Harnett County
420 McKinney Pkwy
LILLINGTON, NC 27546
Phone:
Fax:

SUBJECT: SFD2306-0103
SINGLE FAMILY DWELLING

Here are the results of all Inspections located at **405 MASON DR:**

MONOSLAB  
FOUNDATION PLAN  
SCALE 1/4" = 1'-0"

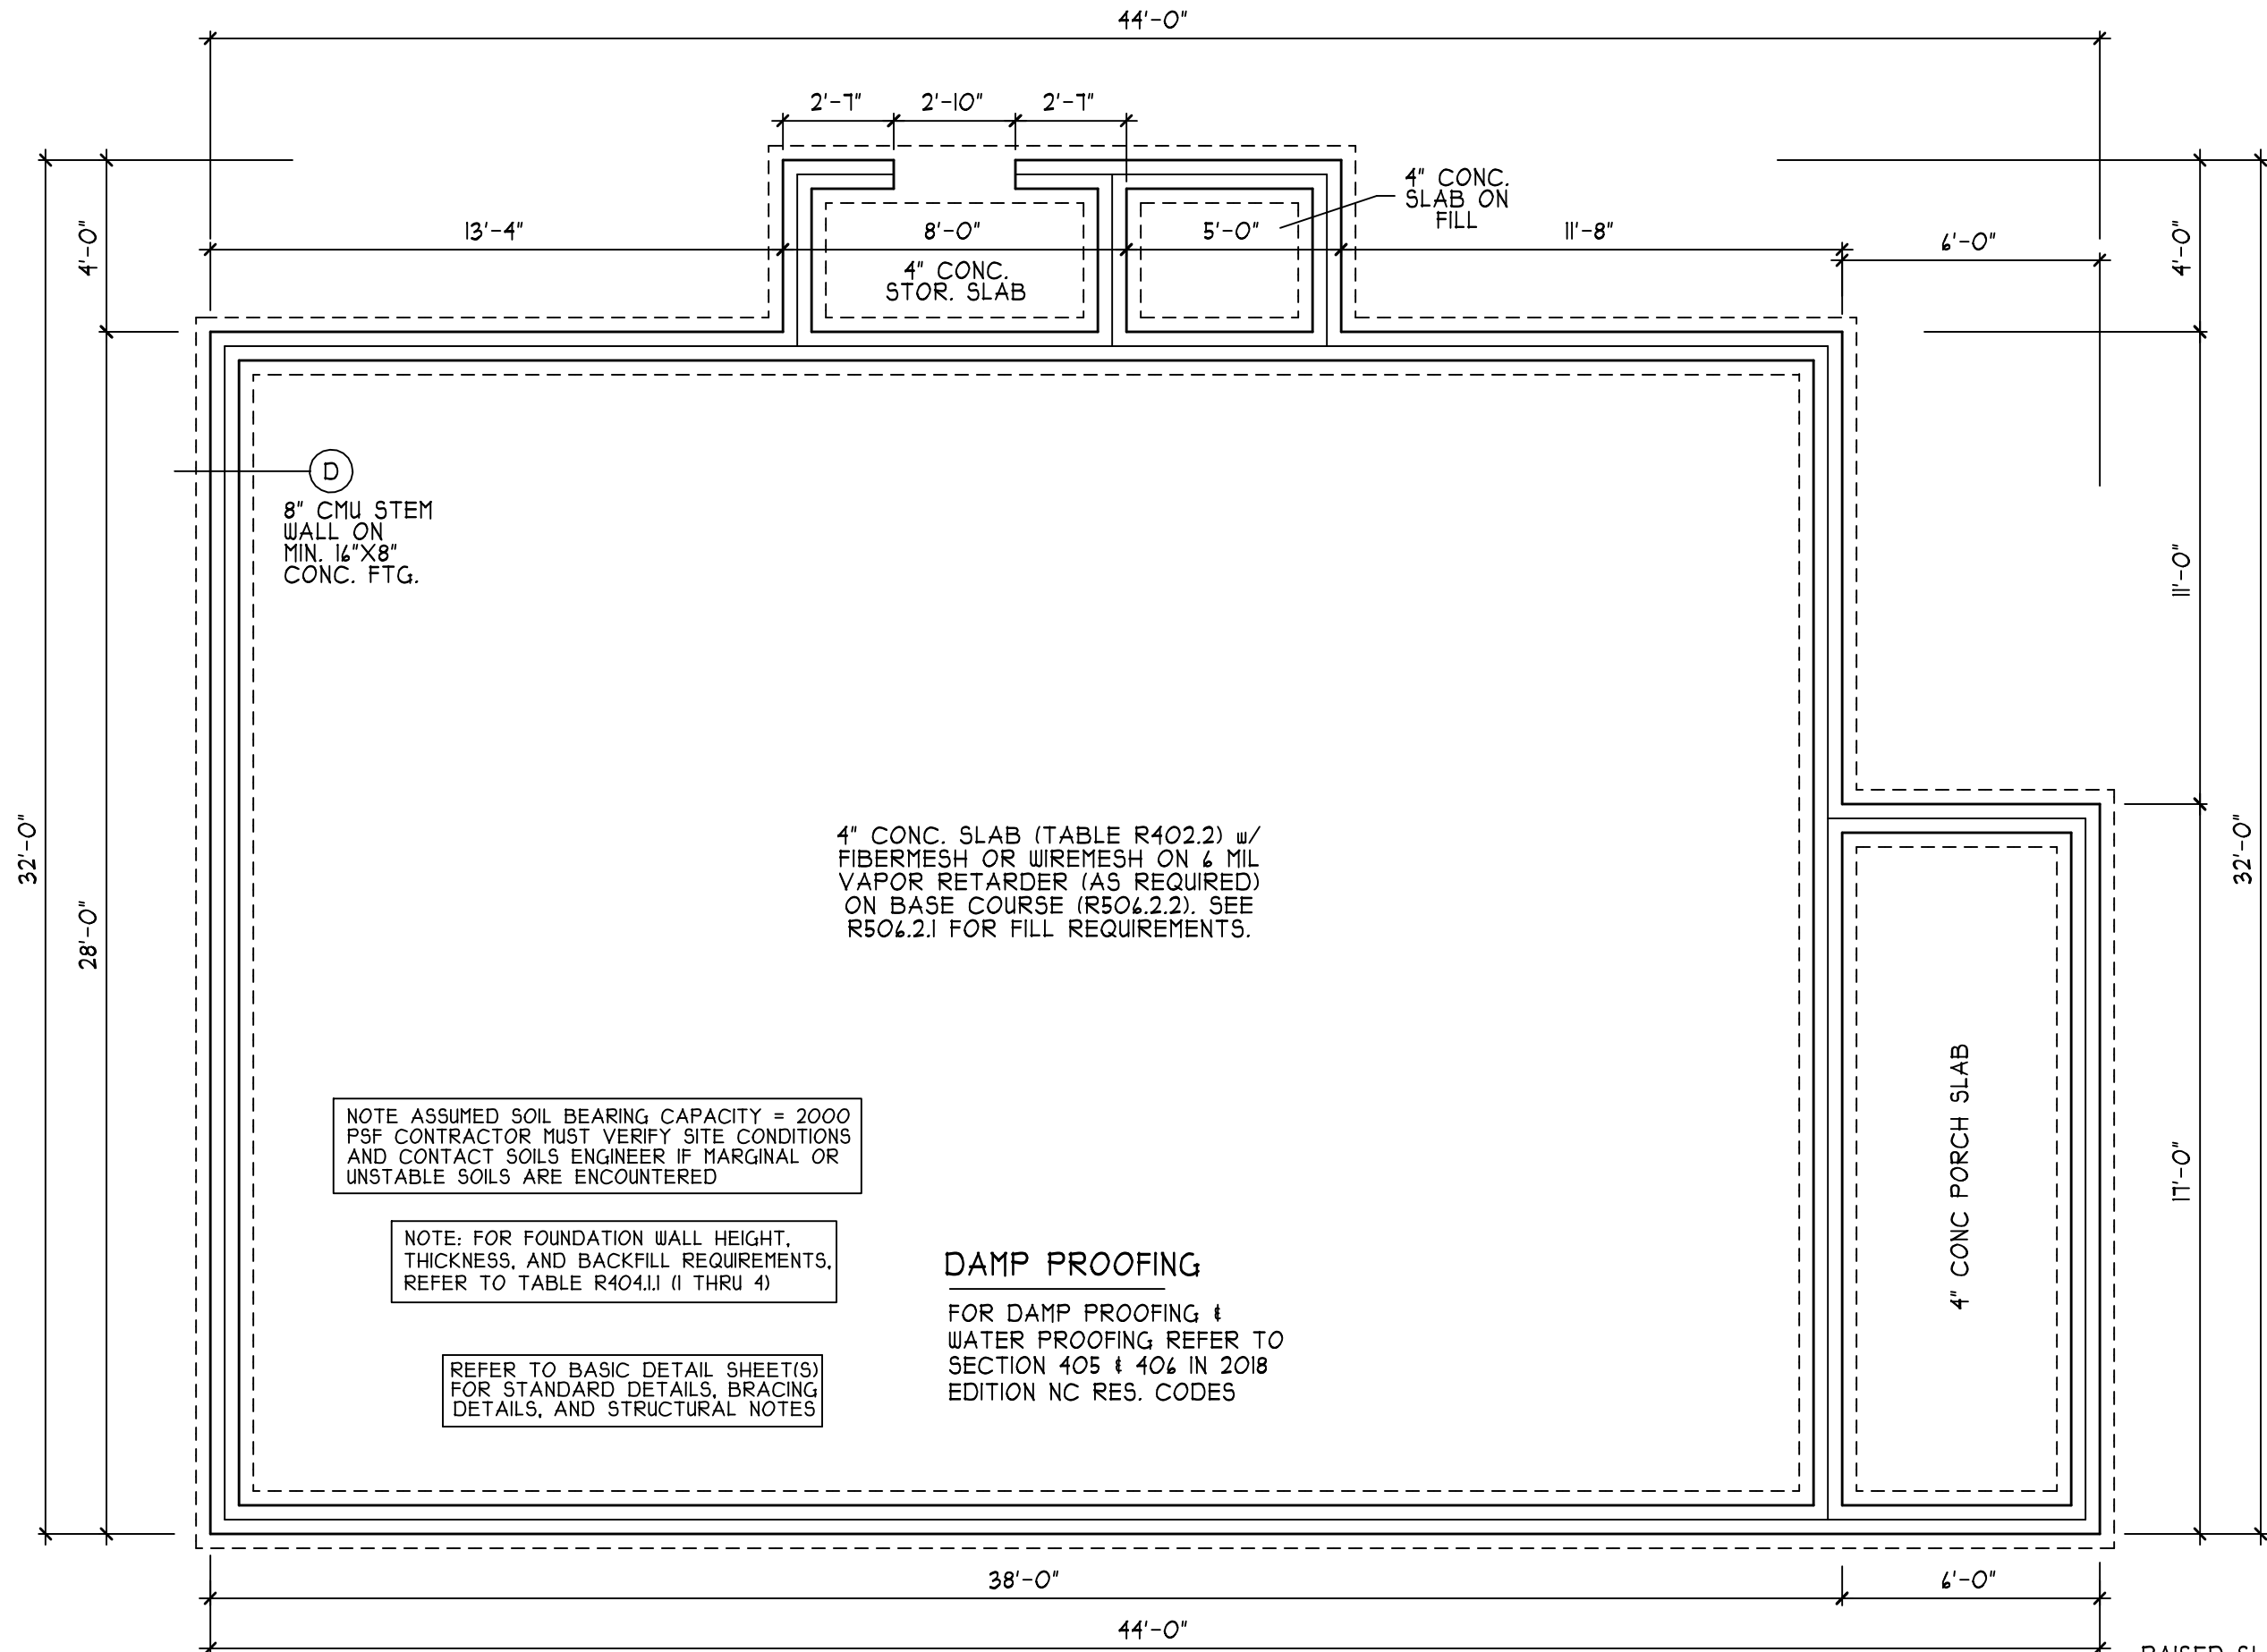
Inspection Type: MONO SLAB
Scheduled Date/Time: 10/12/2023
Completed Date/Time: 10/12/2023
Inspector: Deen Taylor
Result: DISAPPROVED
Remarks:
Notes: see Appendix G
Need engineer form letter for slab

**FIRST FLOOR PLAN**  
SCALE 1/4" = 1'-0"

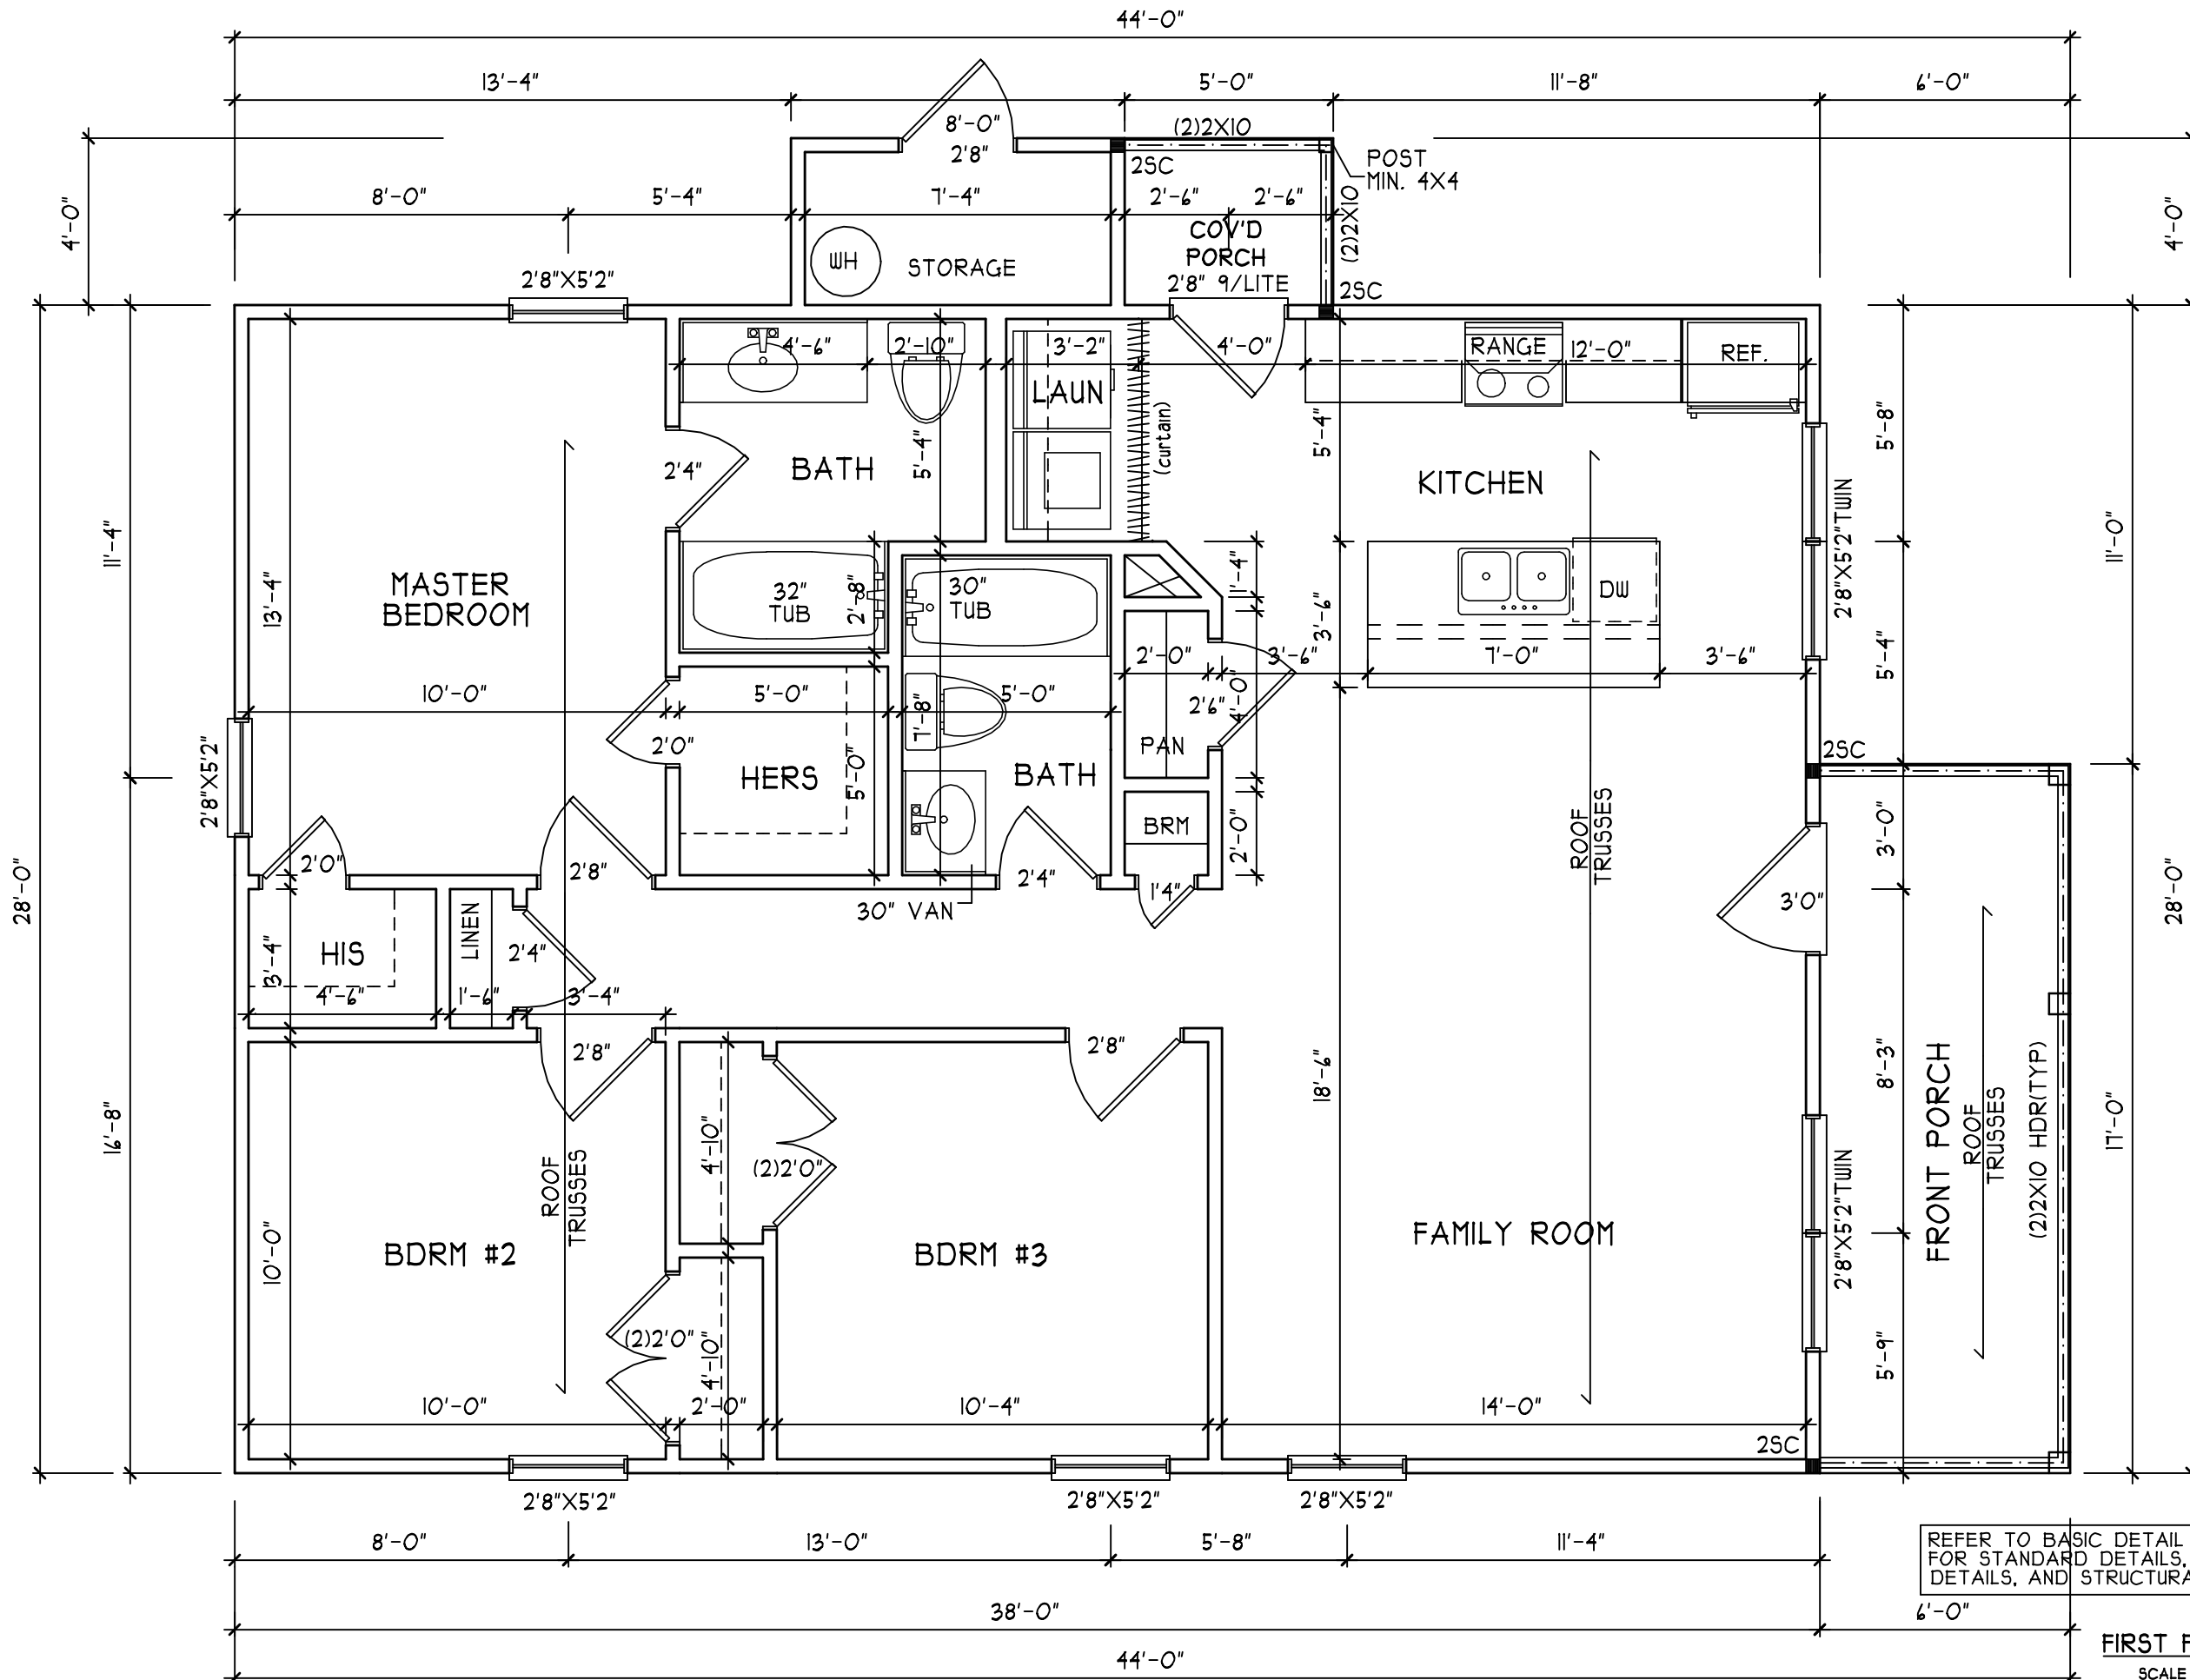
Inspection Type: ROUGH IN REINSPECT
Scheduled Date/Time: 10/25/2023
Completed Date/Time: 10/25/2023
Inspector: Deen Taylor
Result: DISAPPROVED
Remarks:
Notes: Combo is 0426
King stud near front door for front porch support must carry load all the way to slab. Attic access platform must extend all the way to access hole. OK to insulate and side.
